Technical Review – Surface Water  
Assessment (SSD-5765)

# TECHNICAL REVIEW - SURFACE WATER ASSESSMENT (SSD-5765)

| <b>Project:</b> | N1221_001 Bowdens Silver Surface Water Review | <b>Date:</b> | 27 July 2020 |
| <b>Subject:</b> | Surface Water Review – Technical Comments     |              |              |

Figure 6.9 - 1% (1 in 100) AEP peak flood velocities - existing conditions - Lawsons Creek extent

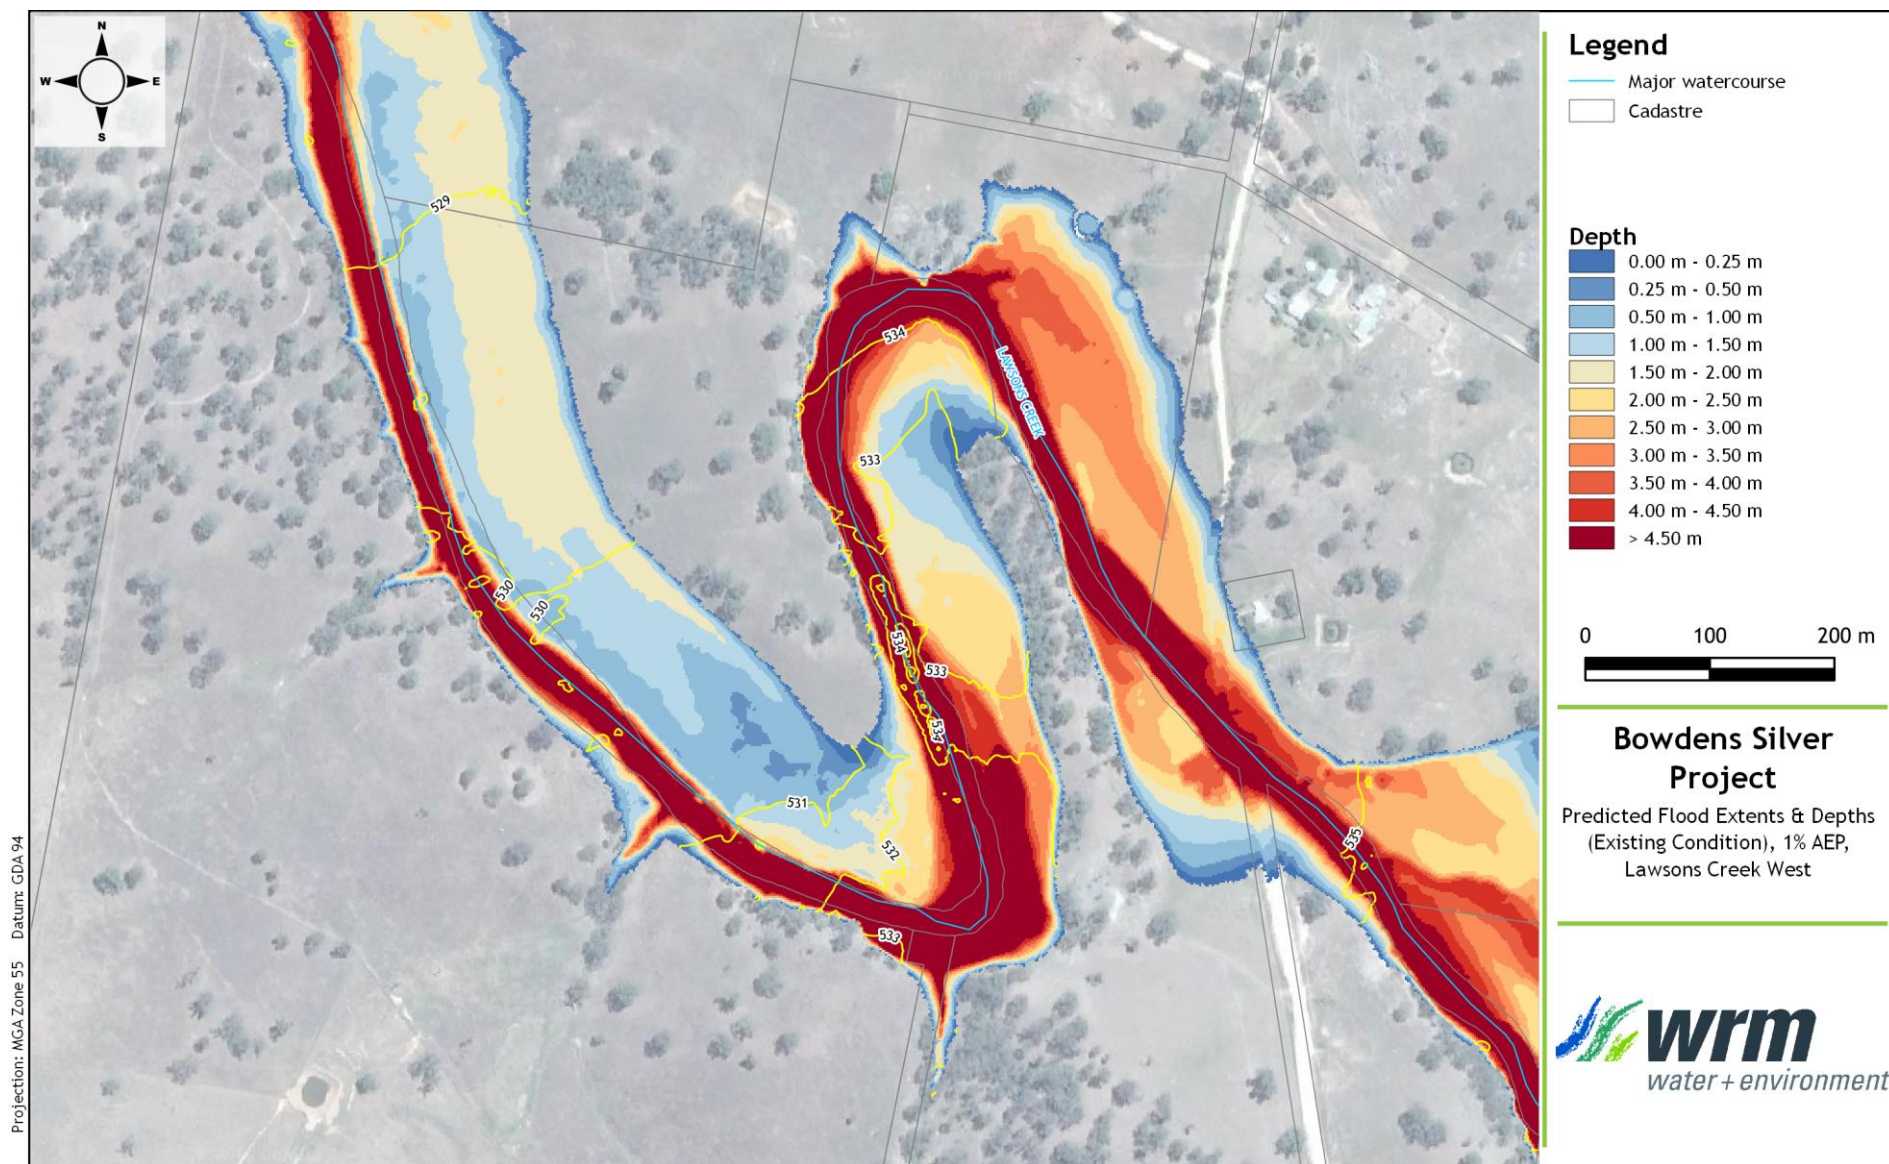
Figure 6.9 1% (1in 100) AEP peak flood velocities – existing conditions – Lawsons Creek extent

Existing conditions only mapped for 1% AEP.

Figure 7.7 - 10% (1 in 10) AEP peak flood levels and depths along Lawsons Creek in the vicinity of the proposed Lawsons Creek Crossing - Lawsons Creek Crossing Scenario

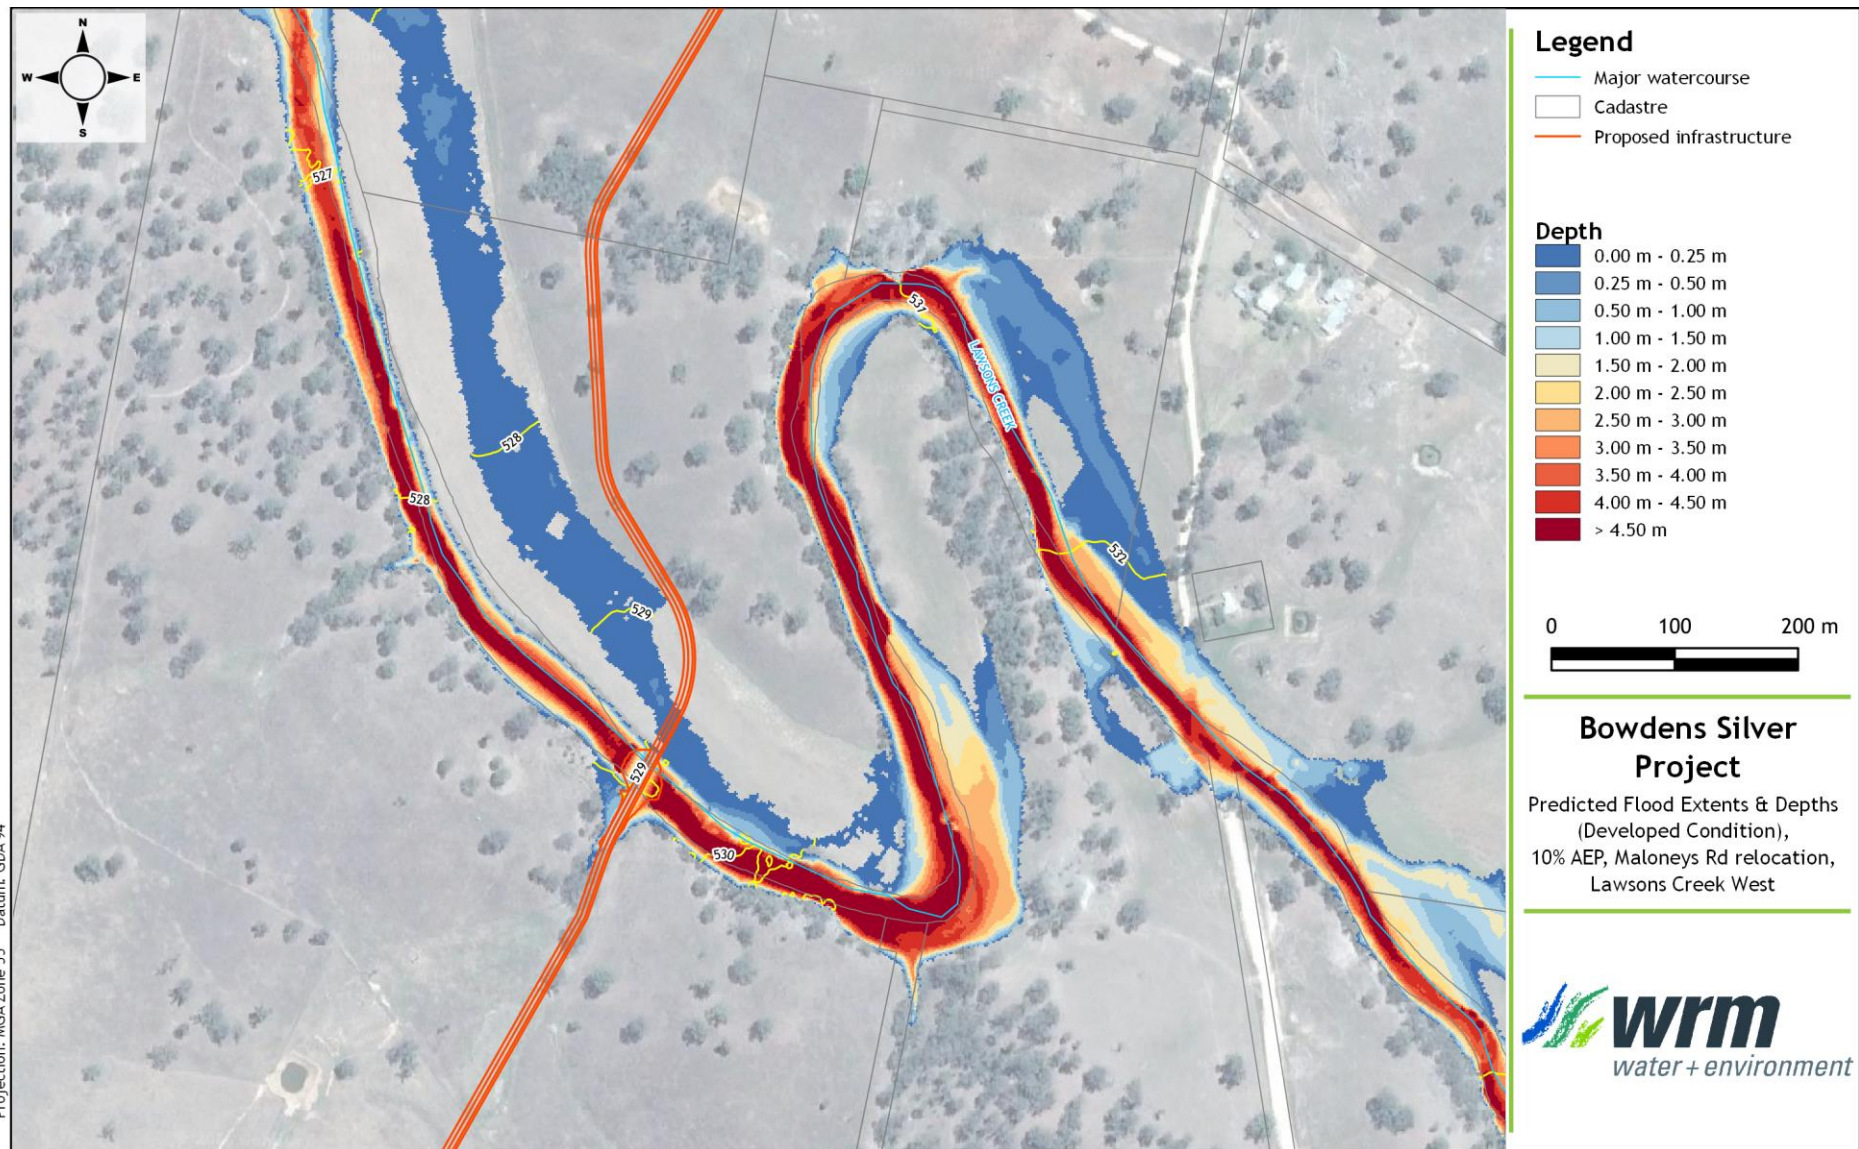
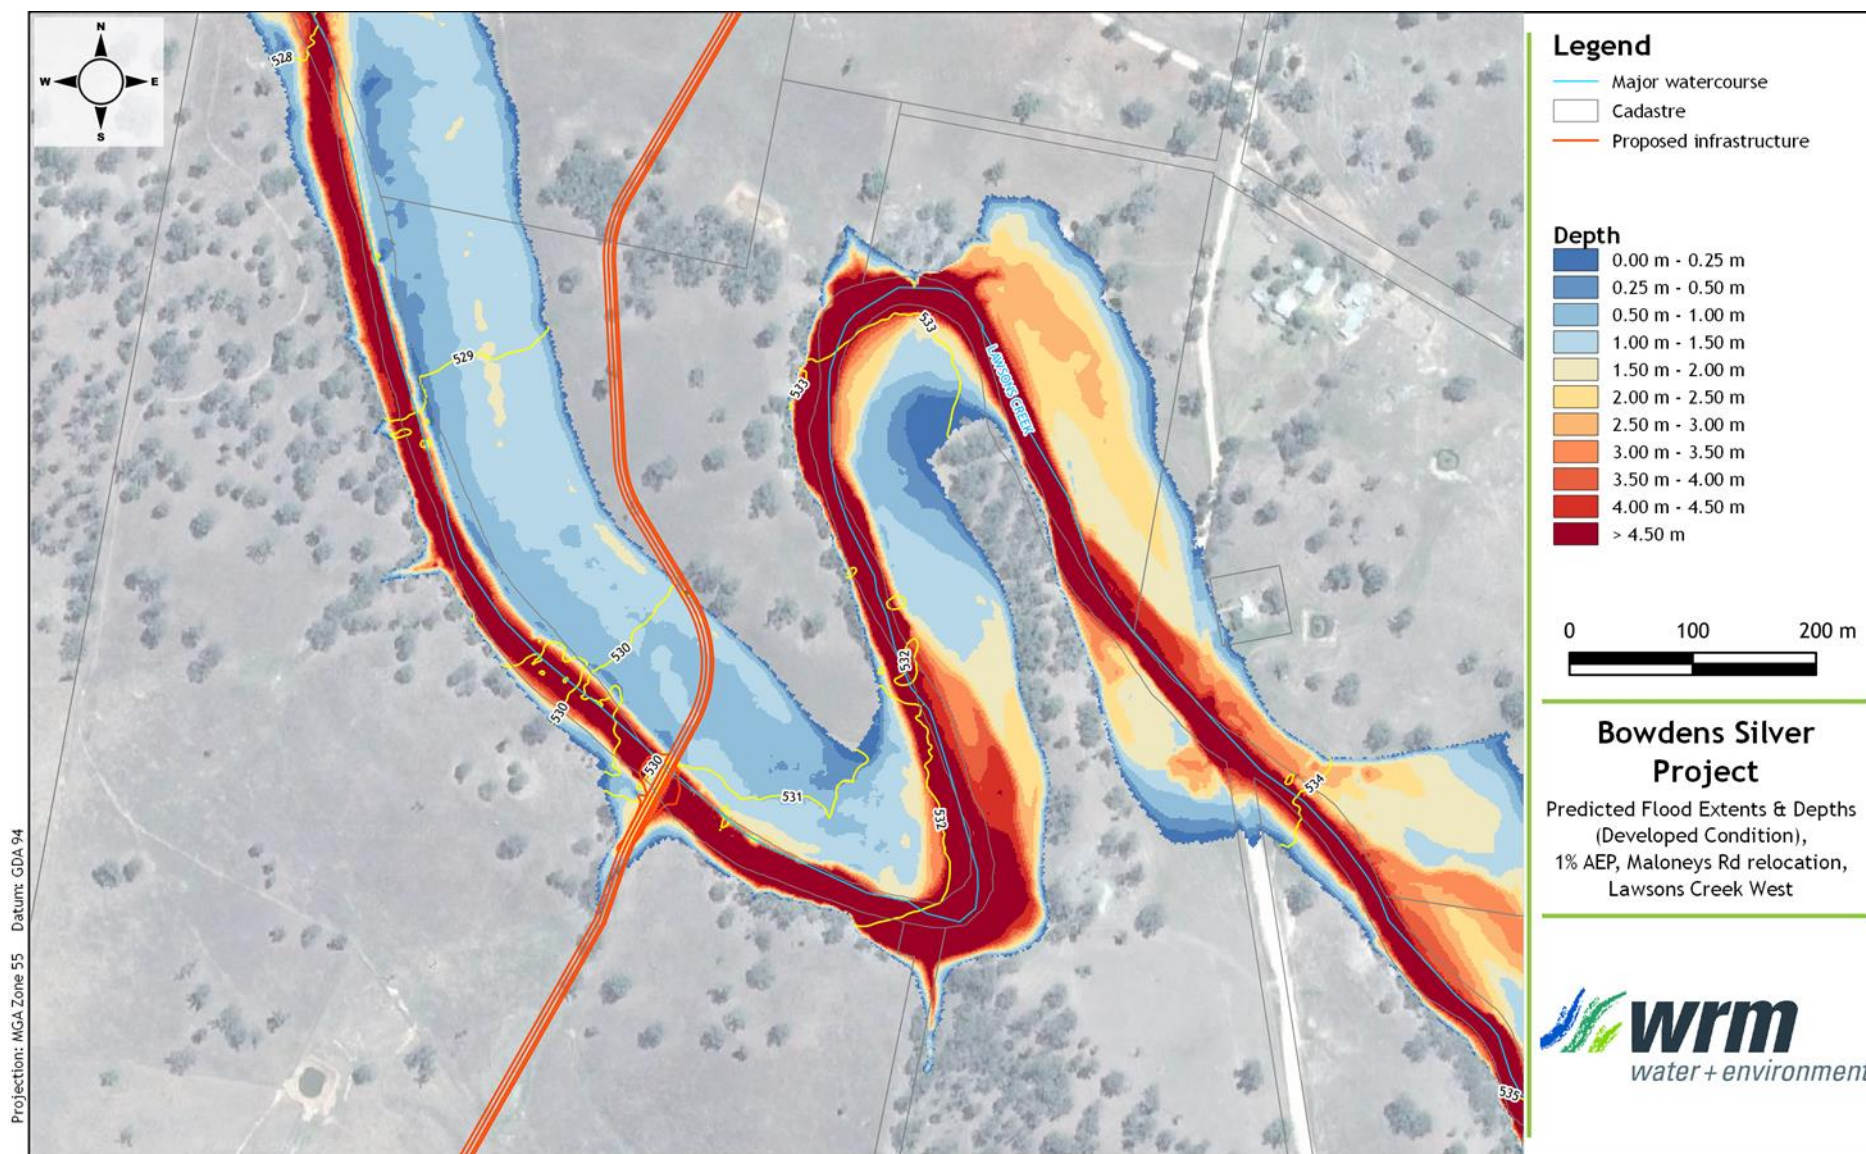
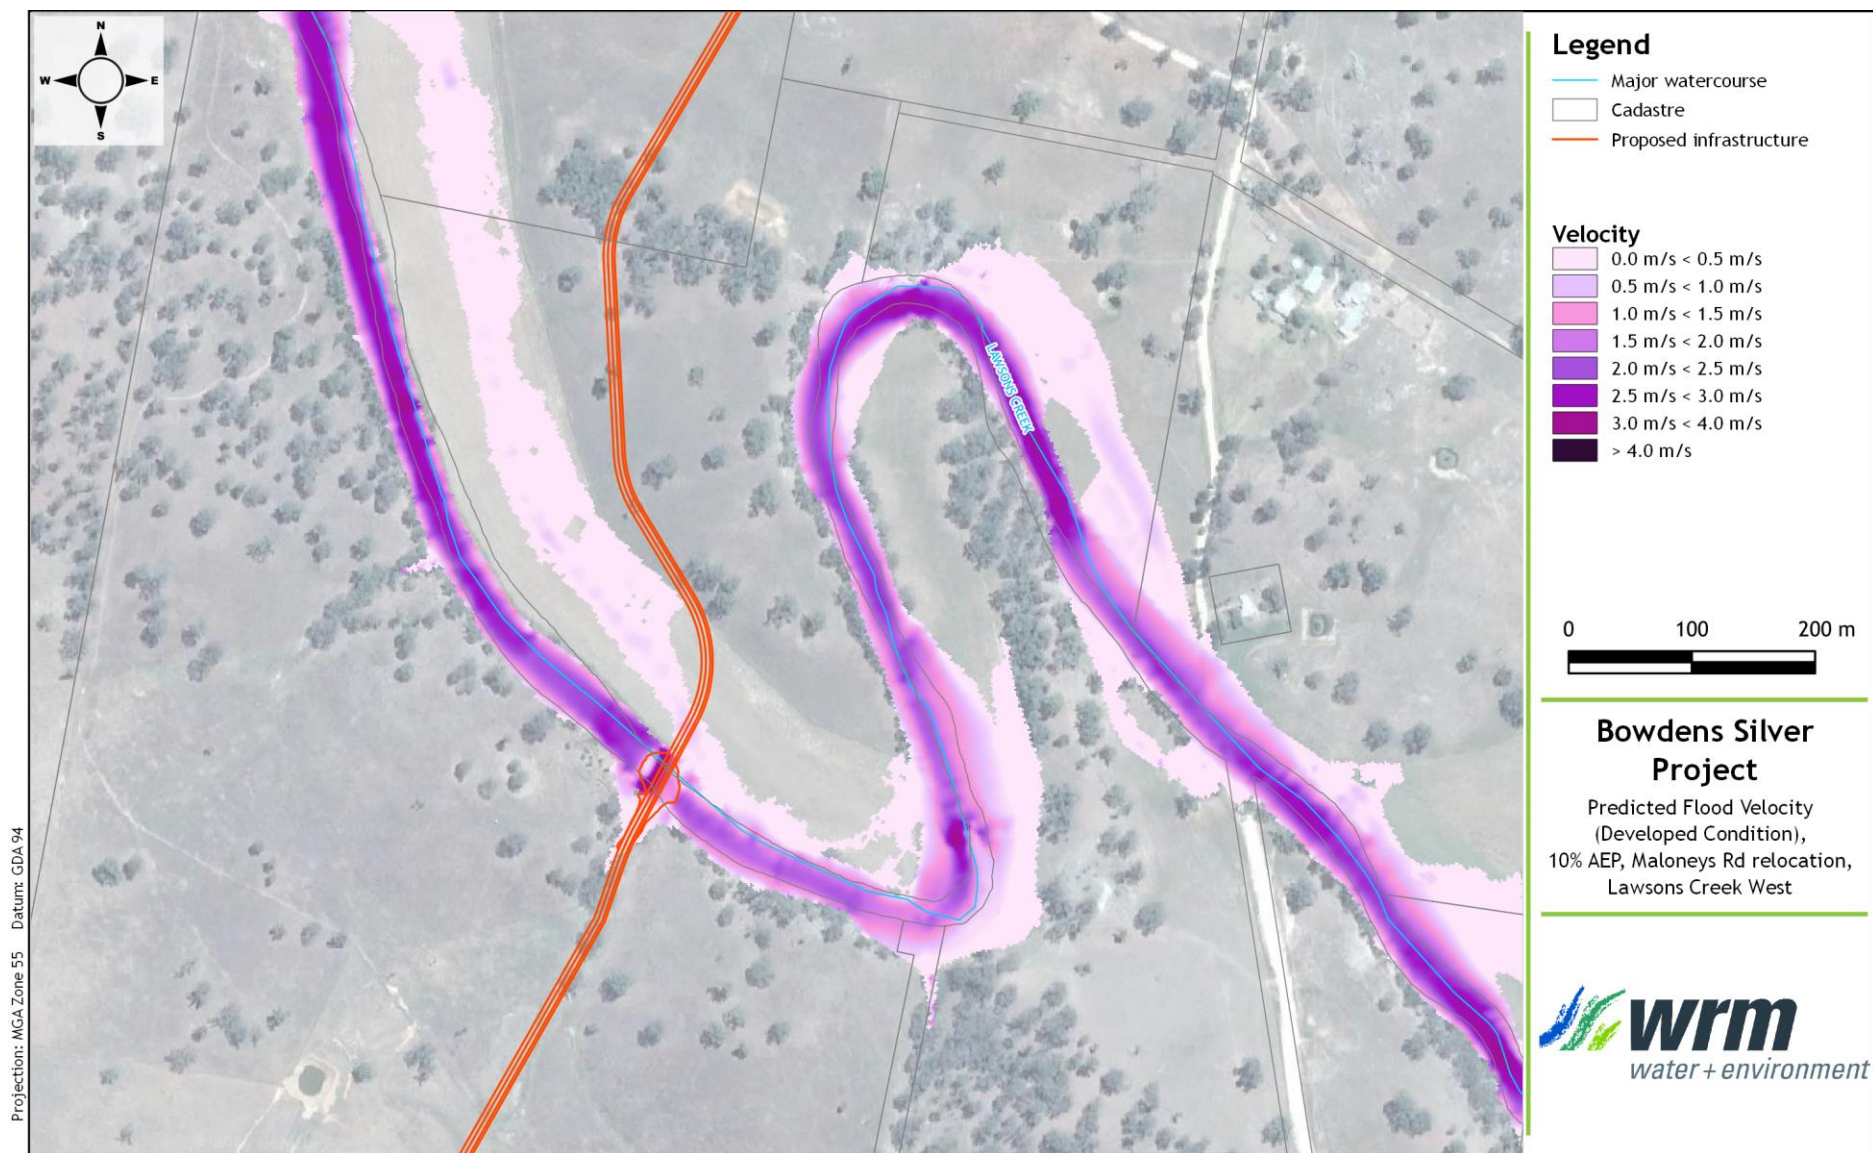
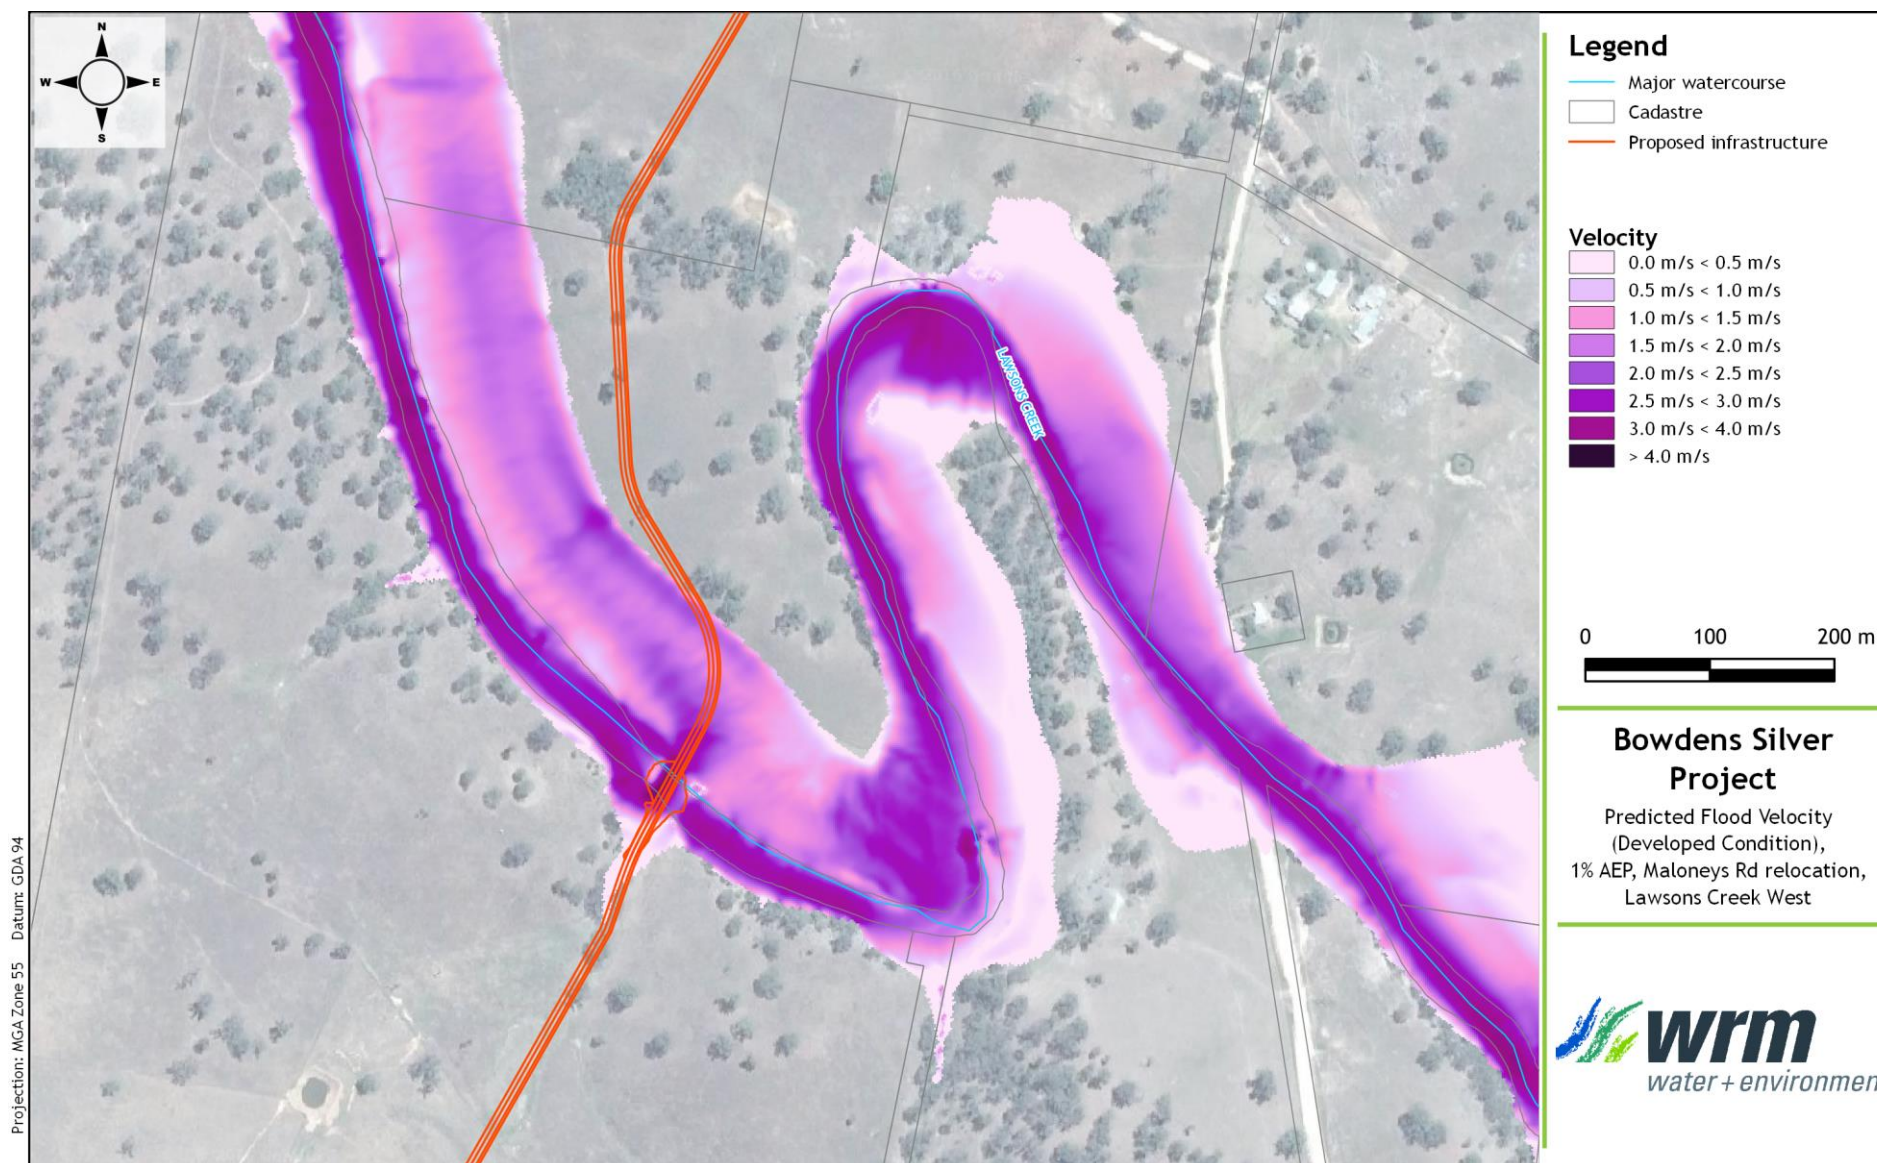
Developed – with Lawsons Road crossing only mapped for 10% AEP.

Break out zone downstream of new crossing increases flood extent for 10% and 2%. Increases in velocities. What are the likely impacts to the floodplain of the increased frequency of inundation?
